Department for  
Business, Energy  
& Industrial Strategy

Our ref EN010077

Date: 20 December 2021

**Application by East Anglia ONE North Limited (“the Applicant”) for an Order granting Development Consent for the proposed East Anglia ONE North Offshore Wind Farm and associated offshore and onshore infrastructure (“the East Anglia ONE North project”)**

| Figure | 1                           |                      |  |

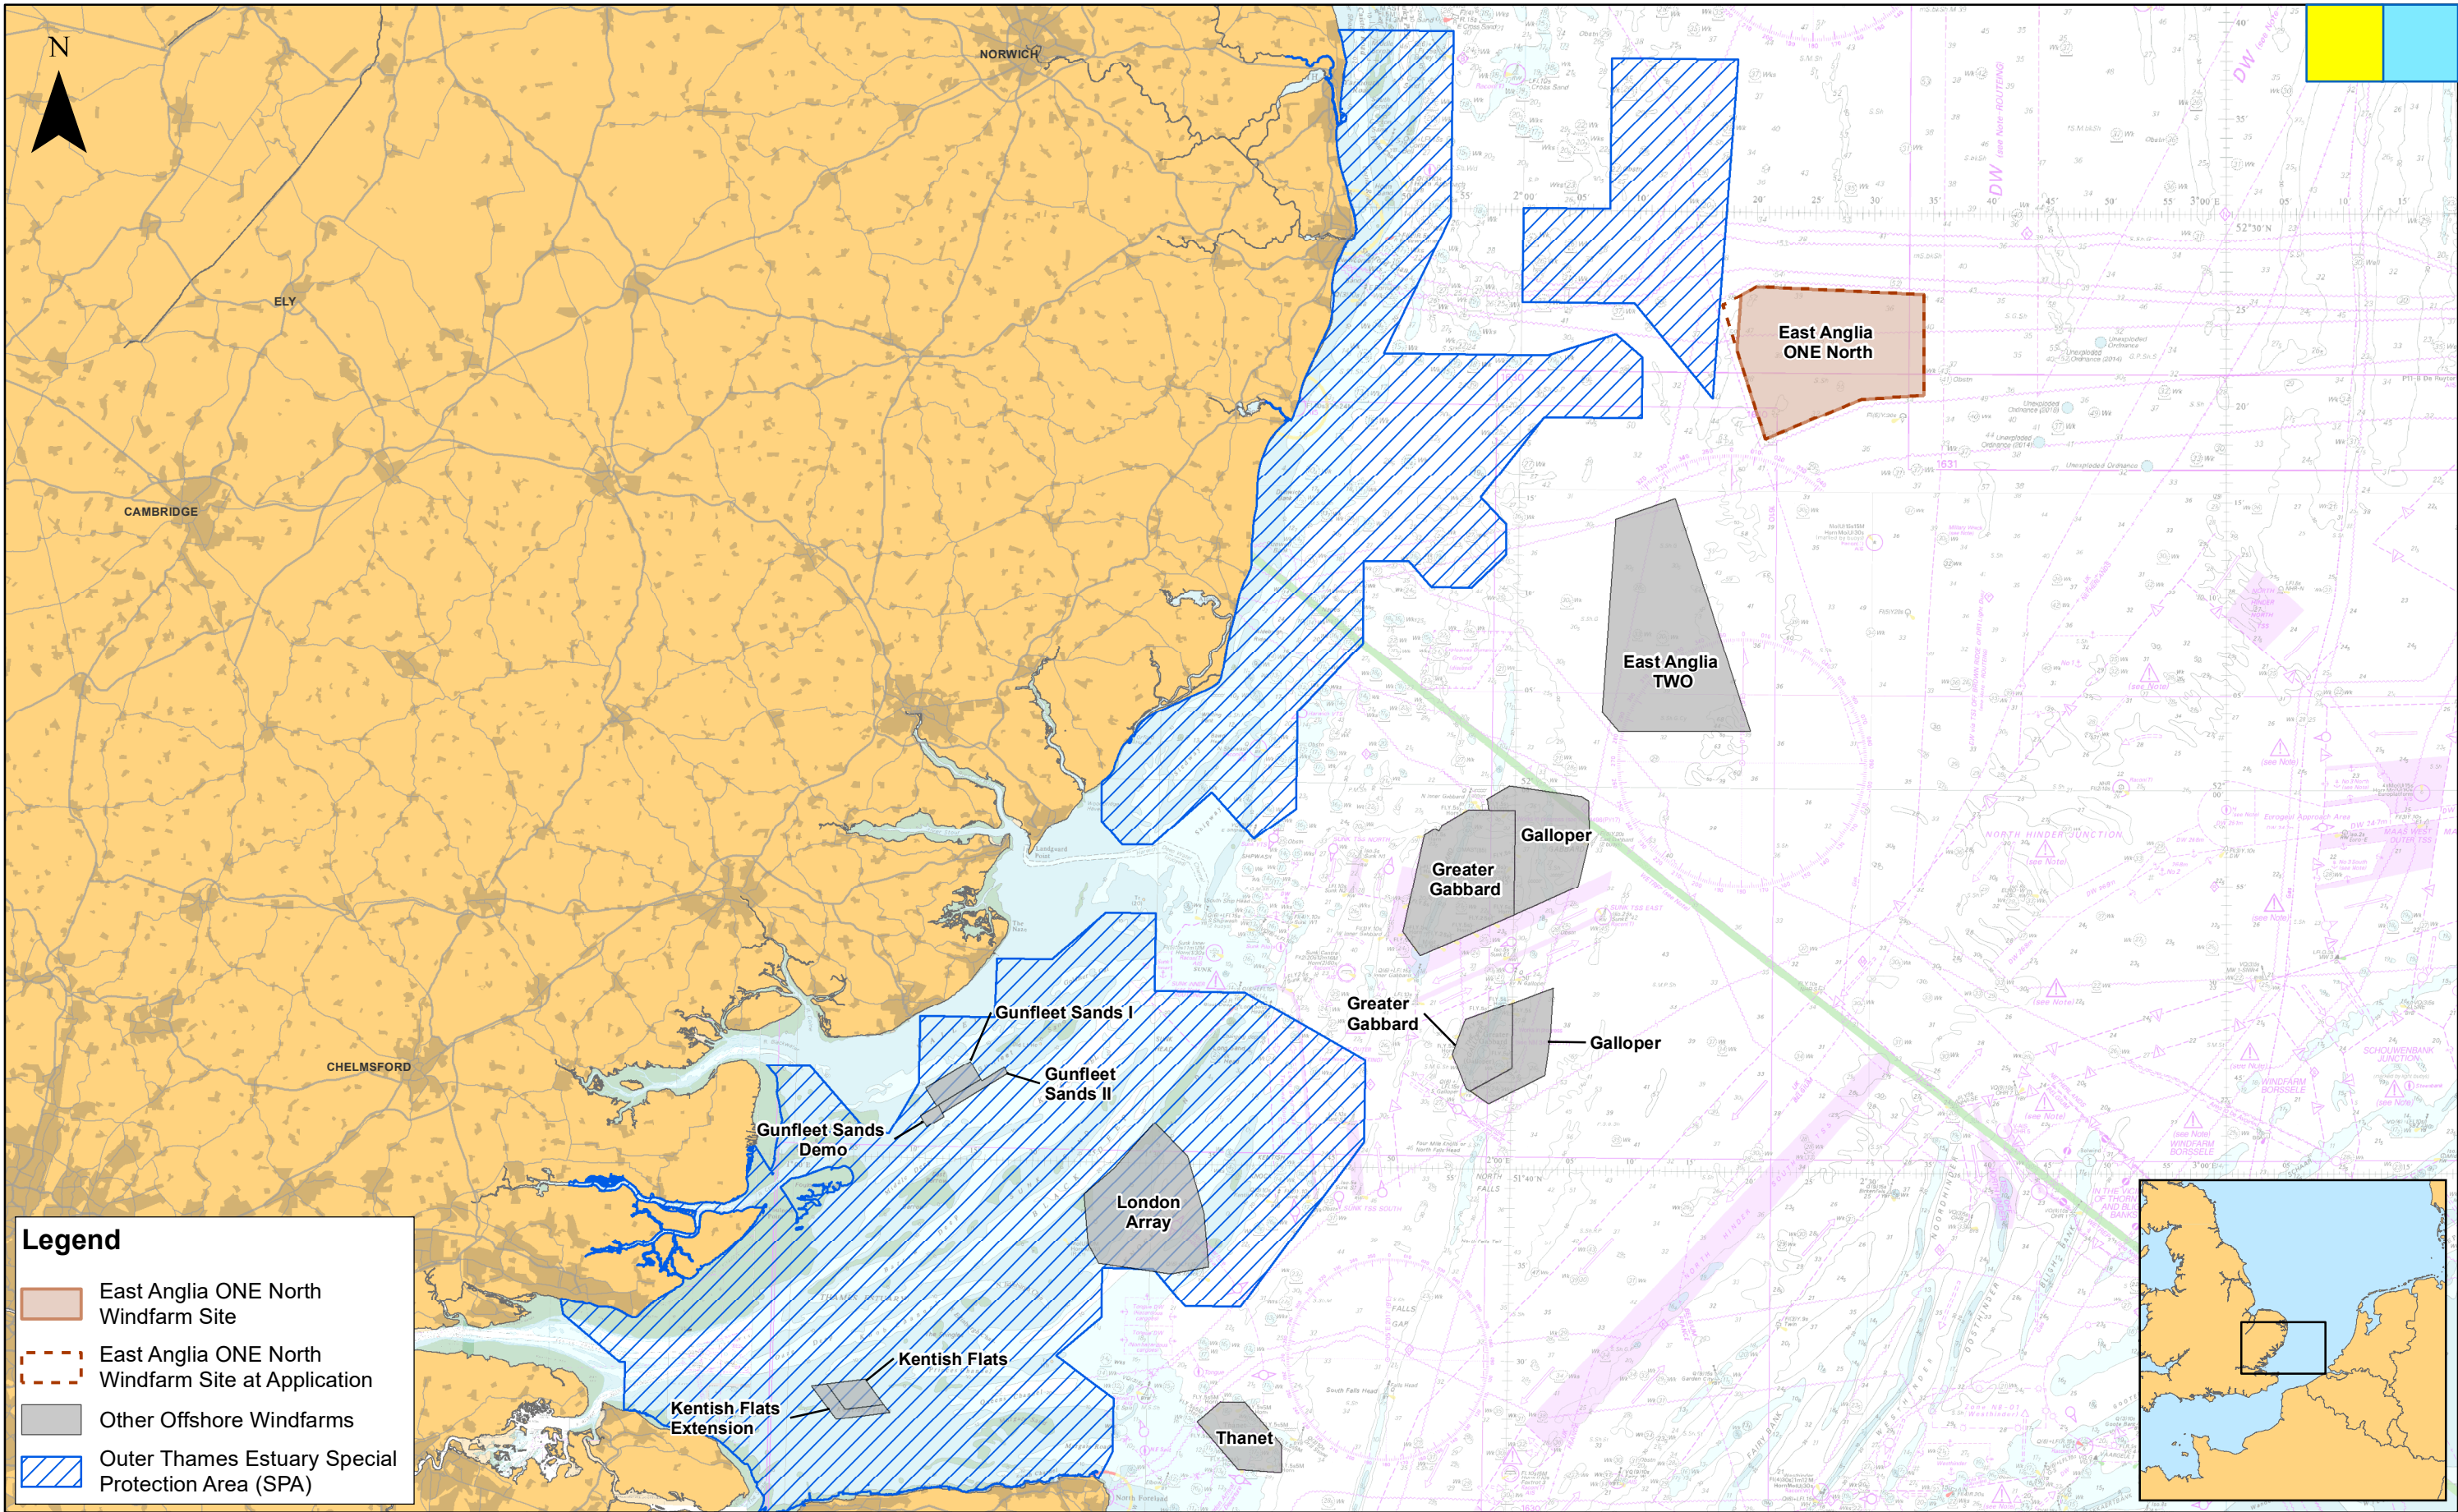
In relation to the red-throated diver feature of the Outer Thames Estuary Special Protection Area (“SPA”), **the Applicant**, in consultation with **Natural England**, is requested to provide an updated project layout that includes a sufficient buffer between the array and the SPA boundary to remove displacement impacts on red-throated divers within the SPA.
